From: Anita Gardner <Anita.Gardner@arun.gov.uk>
Sent: 09 October 2020 18:51
To: Planning.Responses <Planning.Responses@arun.gov.uk>
Subject: FW: LU/247/20/PL - 57 River Road, Littlehampton

From: Carl Gulland [REDACTED]
Sent: 09 October 2020 18:31
To: Anita Gardner <Anita.Gardner@arun.gov.uk>
[REDACTED] Geoffrey Murray [REDACTED]
Subject: Re: LU/247/20/PL - 57 River Road, Littlehampton

1908-P-305 North West Elevation - we have seen the correspondence from the owner of the adjacent property at 47 River Road and the concern that the view along the river is partially reduced by the massing of the proposal. It's worth noting that:

DRAWING NO: 1908_P_305 **REVISION 01**

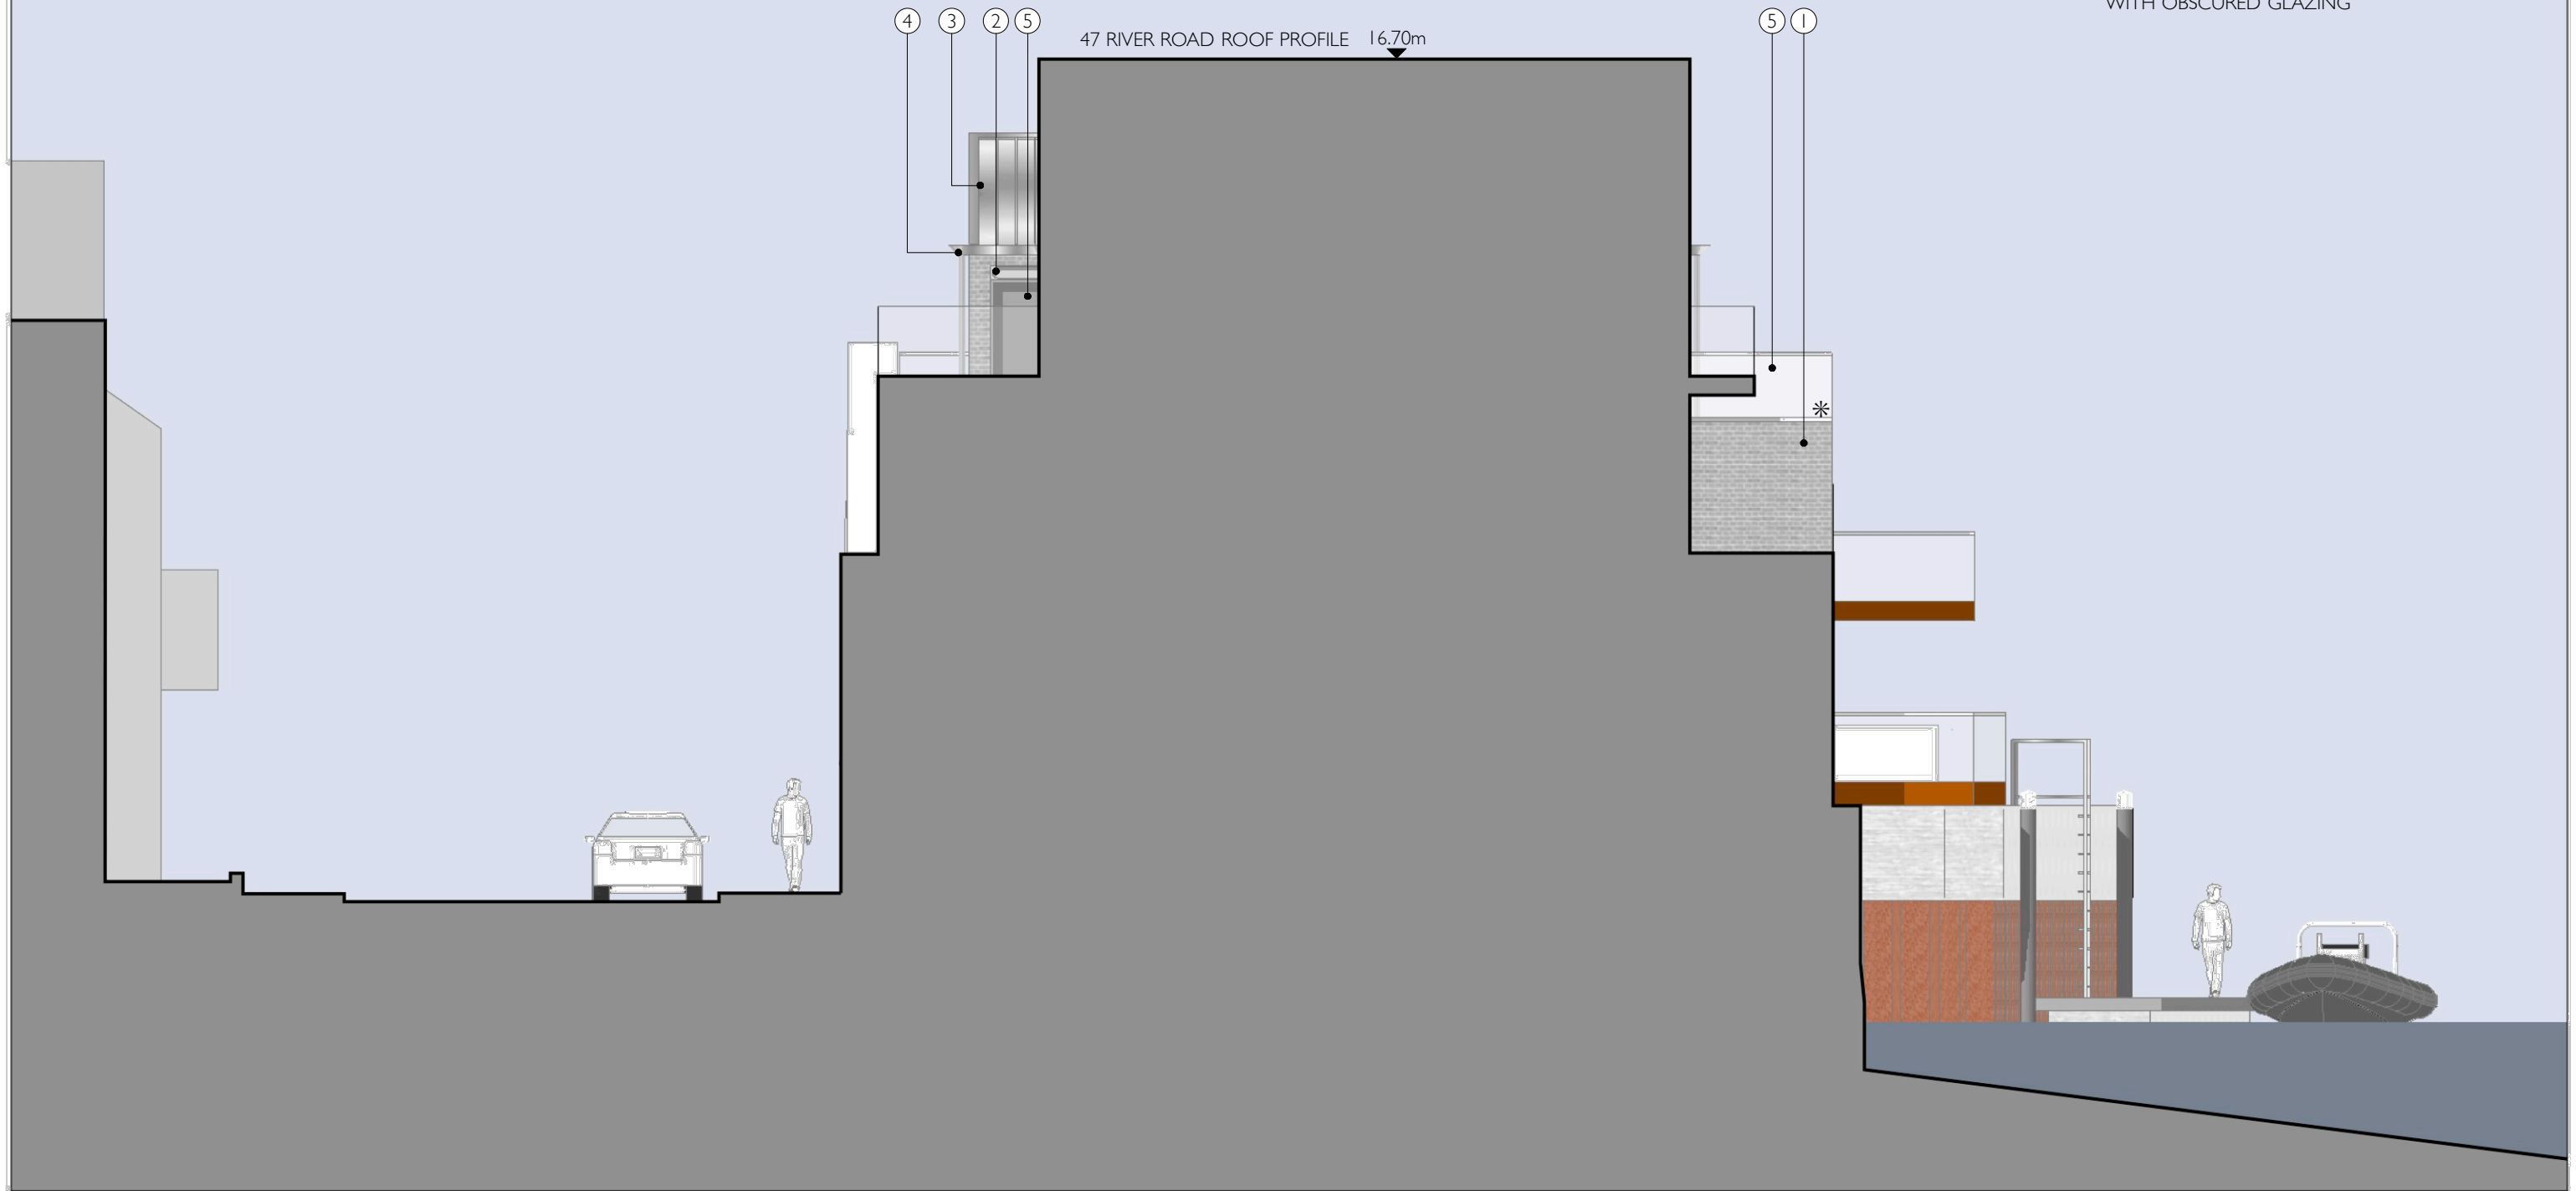
- the other dwellings at 47 River Road have privacy screens between terraces which also limit views along the river
- the proposed flank wall is not full height and will not cut out a significant amount of light to the terrace given the south westerly orientation
- while we appreciate that the owner is objecting to the loss of view we understand that this is not in itself a planning consideration
